Erection of a two storey rear extension, second storey enlargement of side dormer and conversion of garage to study including demolition of existing conservatory
100 Sea Road East Preston

Thank you for your internet representation made on 18th December 2018 which has been recorded as '**an objection**' with the comments as follows:

Proposed Floor Plans, Elevations, Roof Plan and Block Plan

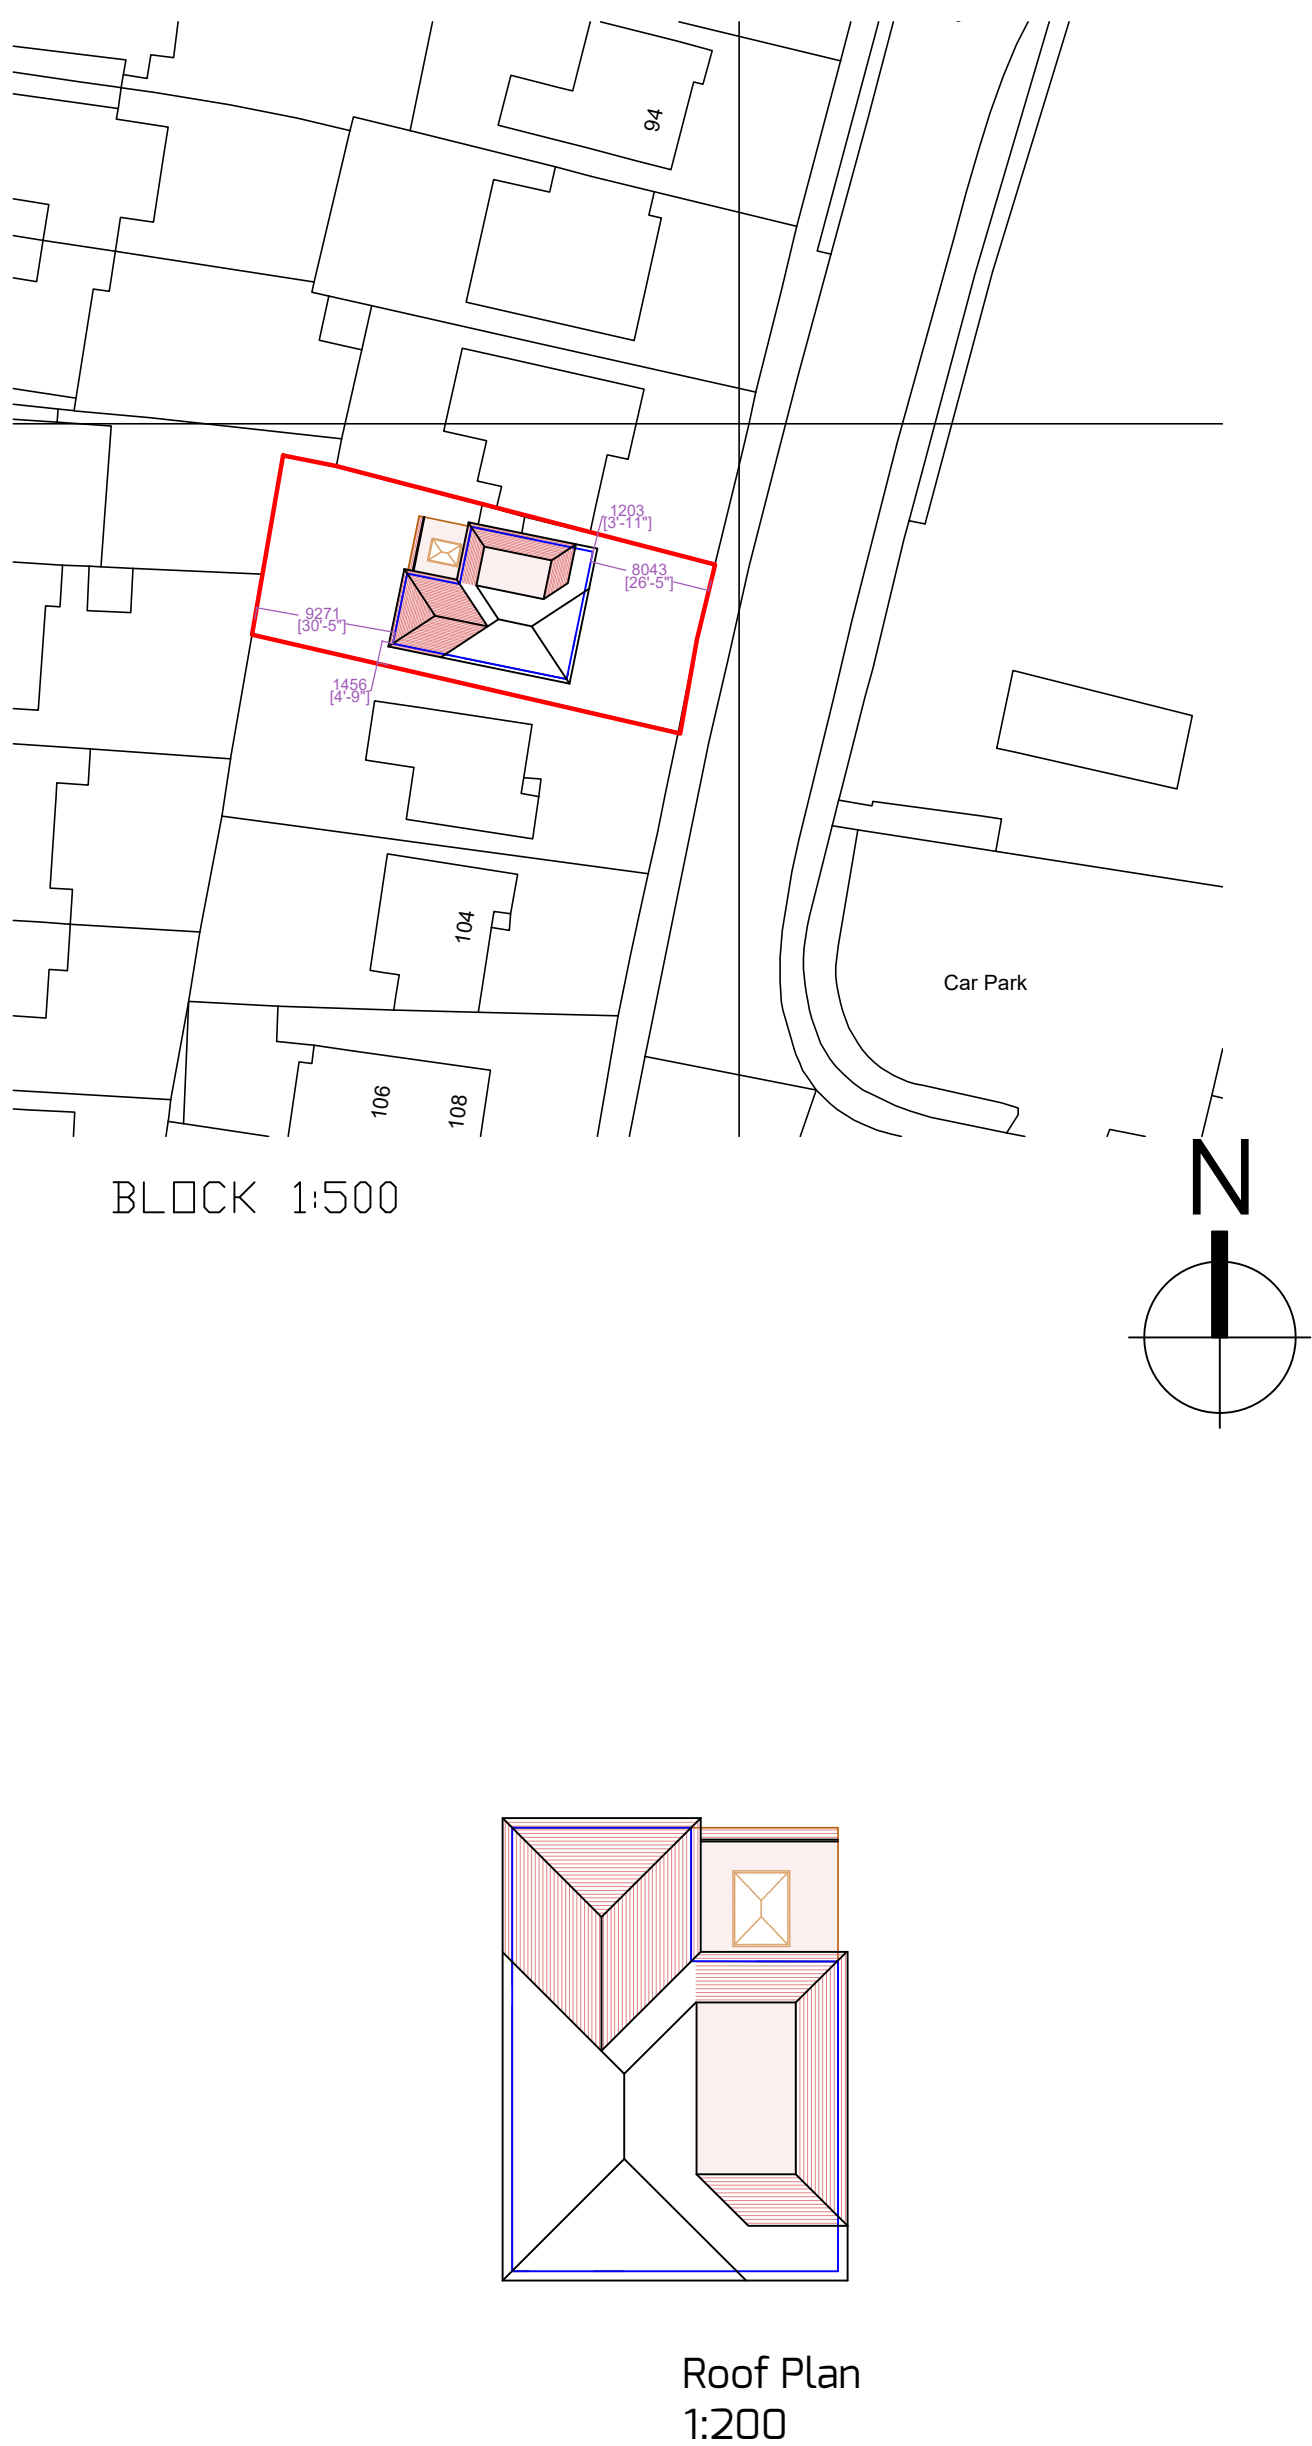
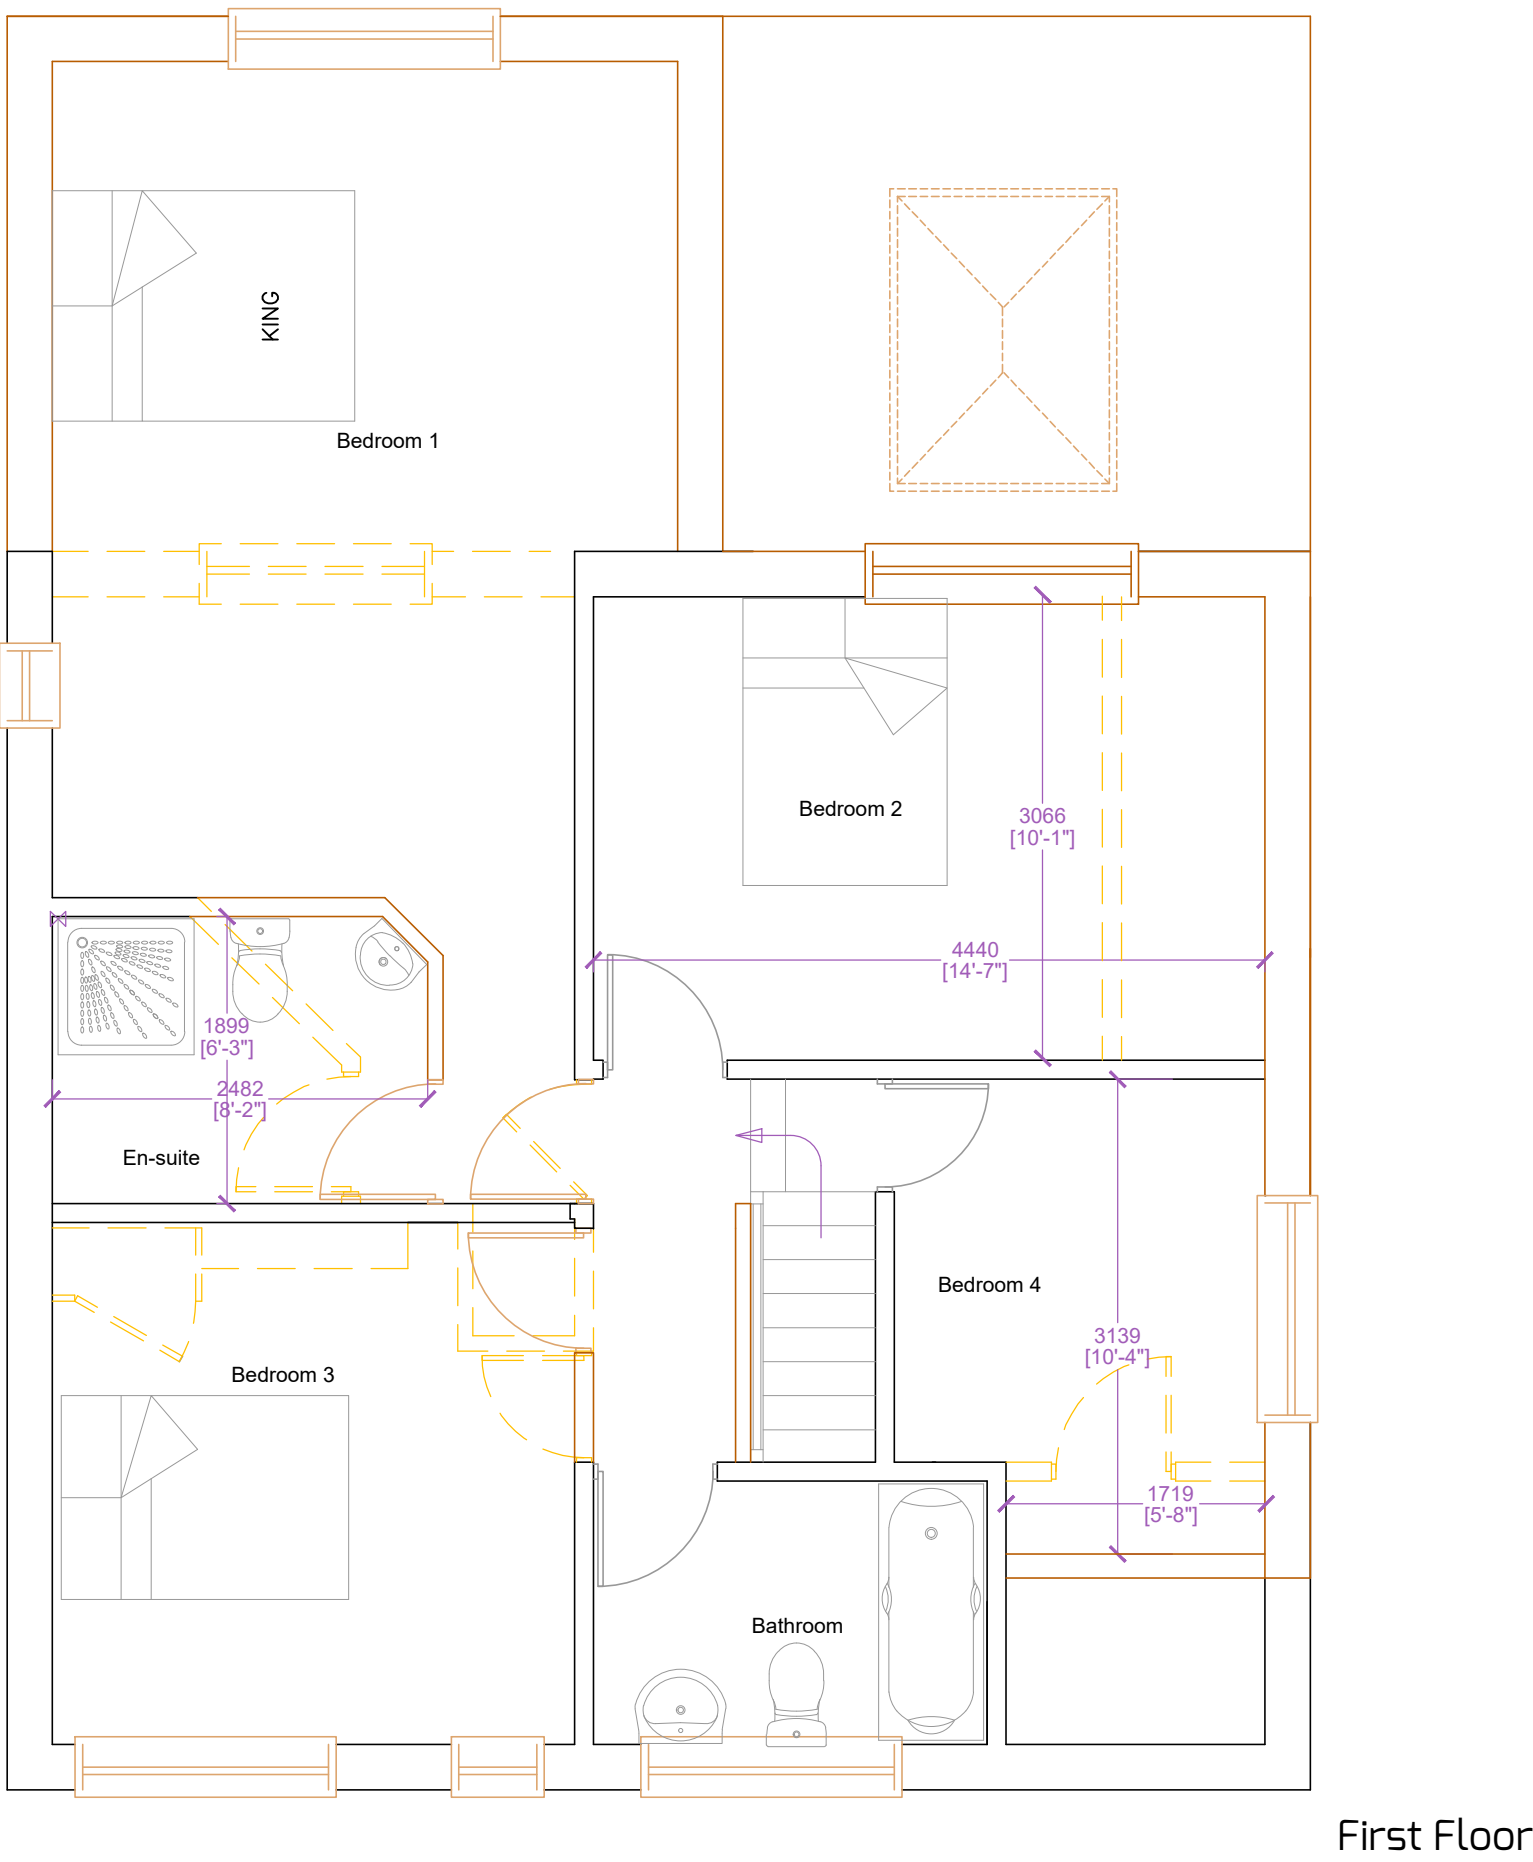
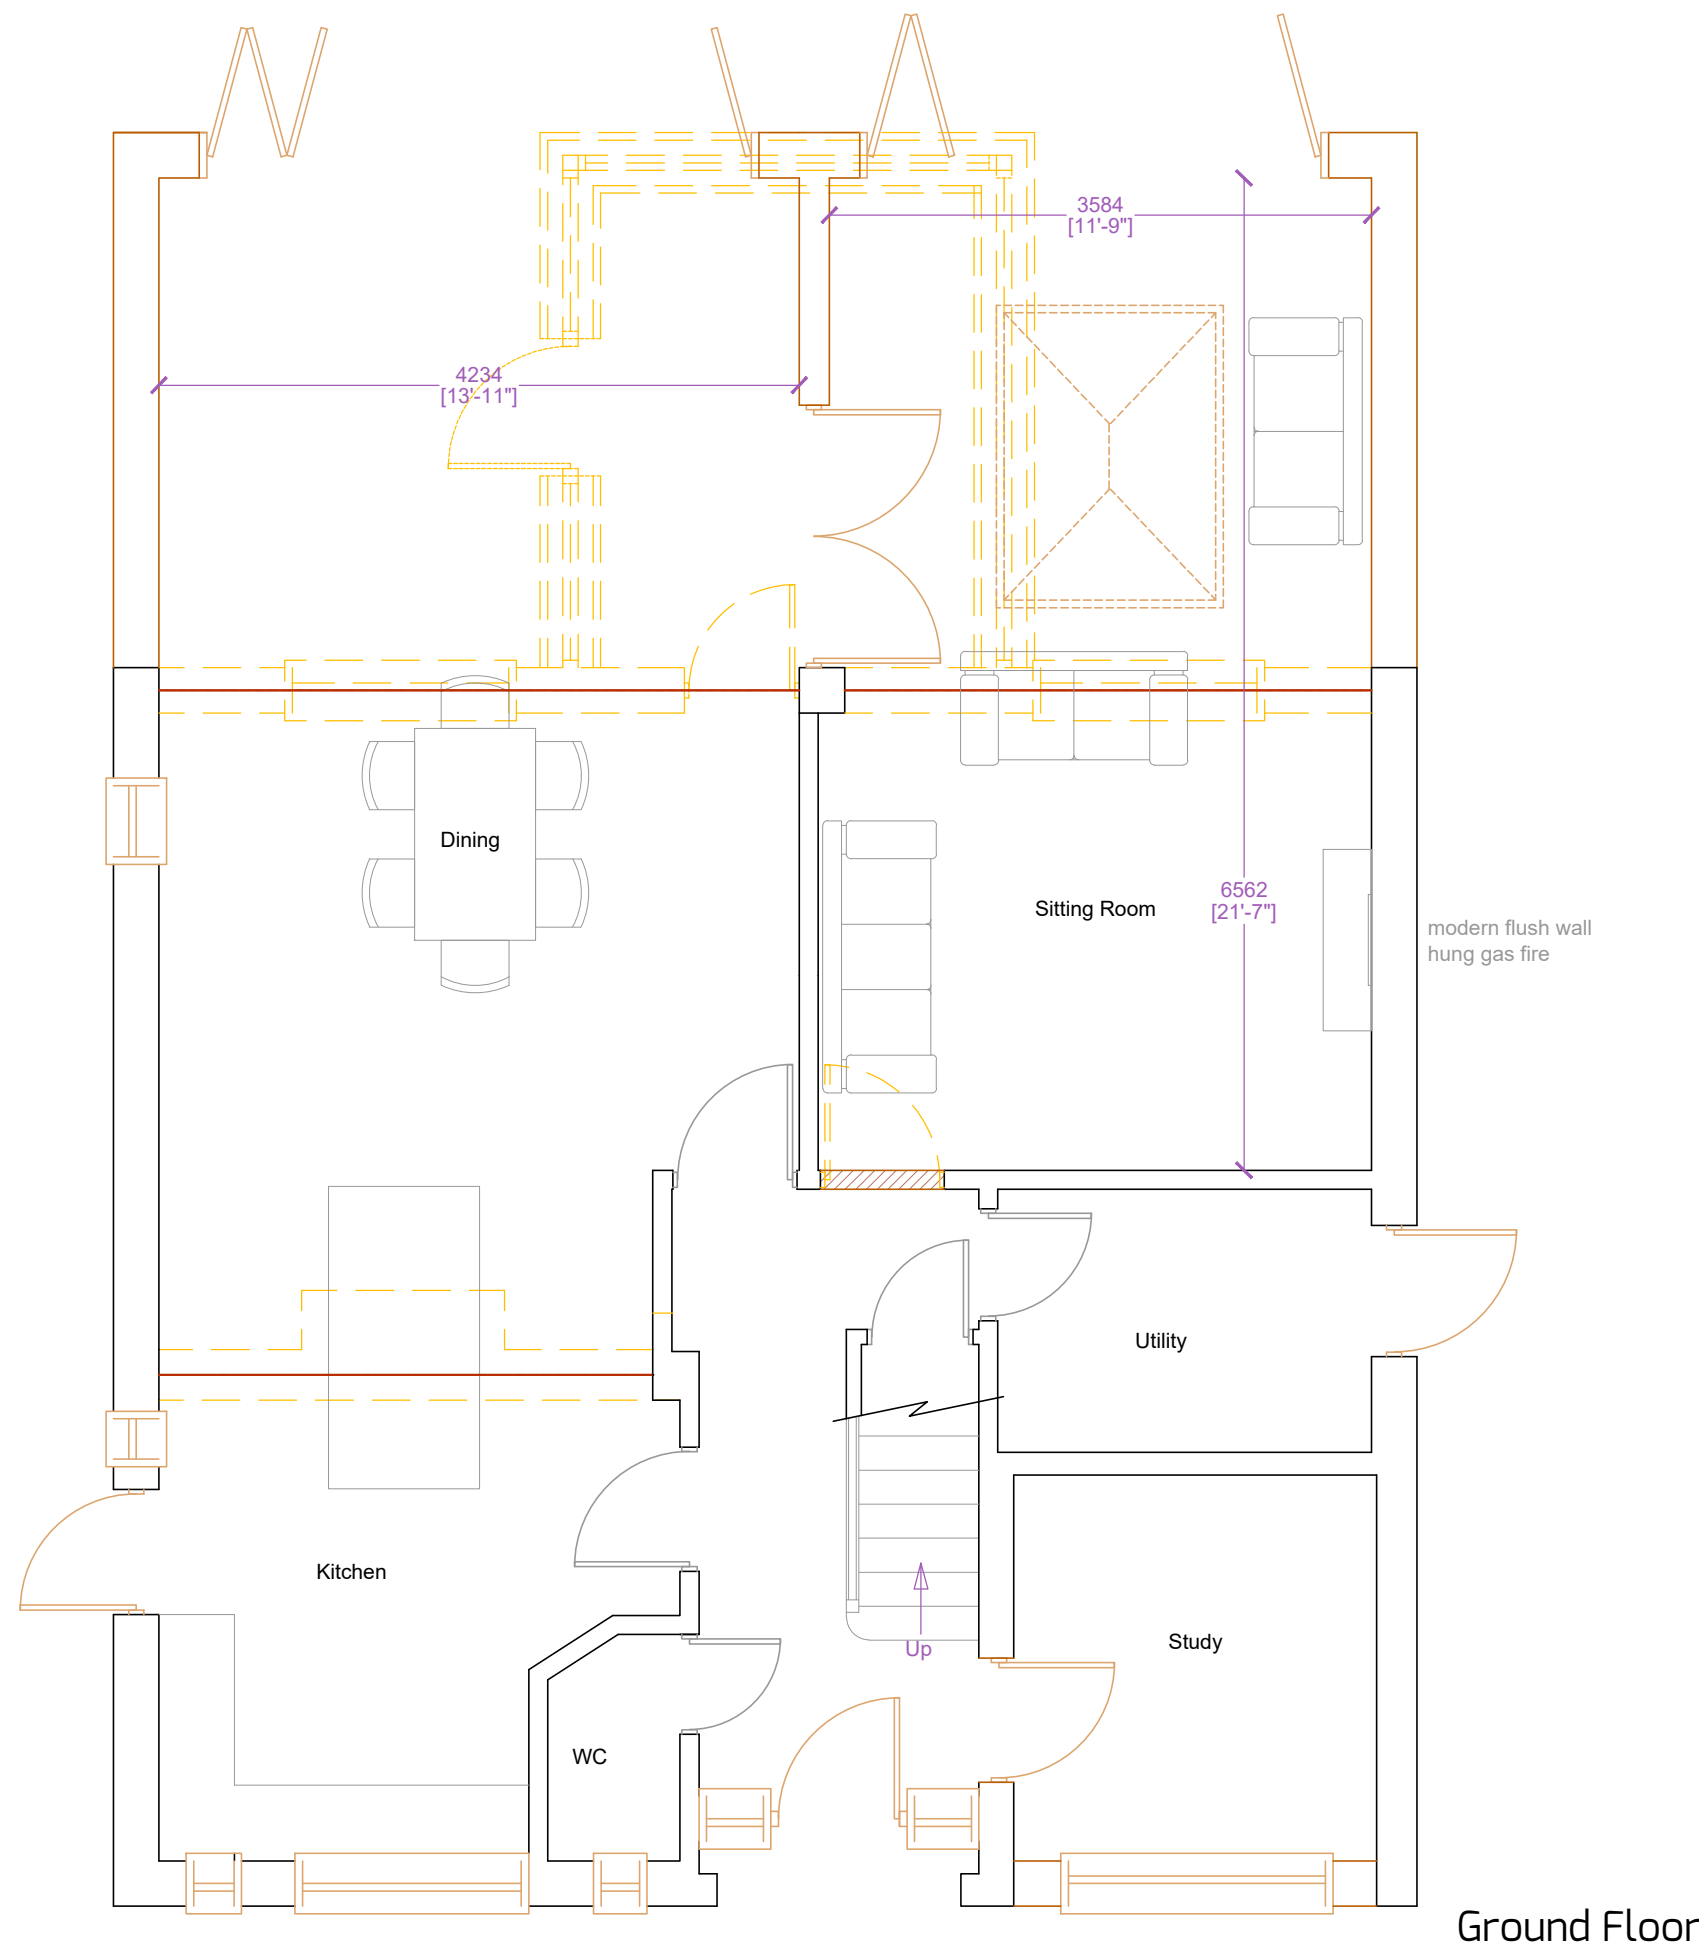
It has been drawn to our attention that the block plans submitted are not correct. There is a side single storey extension to 102 Sea Road which is not shown on the plans submitted. This extension runs alongside the angle of the thick boundary wall and so is narrower at the front and wider at the back.

Our side extension stops at our current building line which is approximately half a metre further forward than 102 Sea Road and this is the point that will be closest to the proposed extension - not the conservatory as indicated on the drawings.

We did not extend further out into our garden because we have double doors opening from our conservatory onto a patio area that will face the brick wall of the proposed extension. The comments we made in our last objection would not have been clearly understood from the original plans submitted because our extension is not shown.

When we submitted our plans our block plan was large and clear on a separate A4 sheet showing all the surrounding gardens including those at the back. However, the block plan presented with this application for public perusal is very small and misleading. It also does not show how the angle of the boundary wall bends in towards the garden of 100 Sea Road meaning that the further the extension comes out the closer to the boundary wall it becomes. Looking at this new information it looks like the new wall of the extension will be less than one metre from our house and that the dimensions given on the plans are not correct.

In light of this new information we also feel that our neighbour's side pathway will be too narrow at the back garden point due to the boundary wall angle and that this could be a problem as they have no access to the other side of their property. The depth of the wall that forms the dividing boundary is not shown on the plans but it has pillars which are 32cm square and topped with 36cm caps. We had to take special precautions when digging our foundations to ensure no damage was done to this wall because it surrounds 100 Sea Road and is a feature of the property as mirrored in other houses in Sea Road. We have had to make these additional points and seek professional guidance at this late stage because initially we did not notice the discrepancies on the plans submitted and feel they are confusing. The front elevation shown on the plans face East not West, the depth of the boundary wall and angle is not clear, our extension is not shown and we are told there could be consideration for the 45 degree rule from the window at the back of our side extension but because the current plans are not up to date this cannot be established.
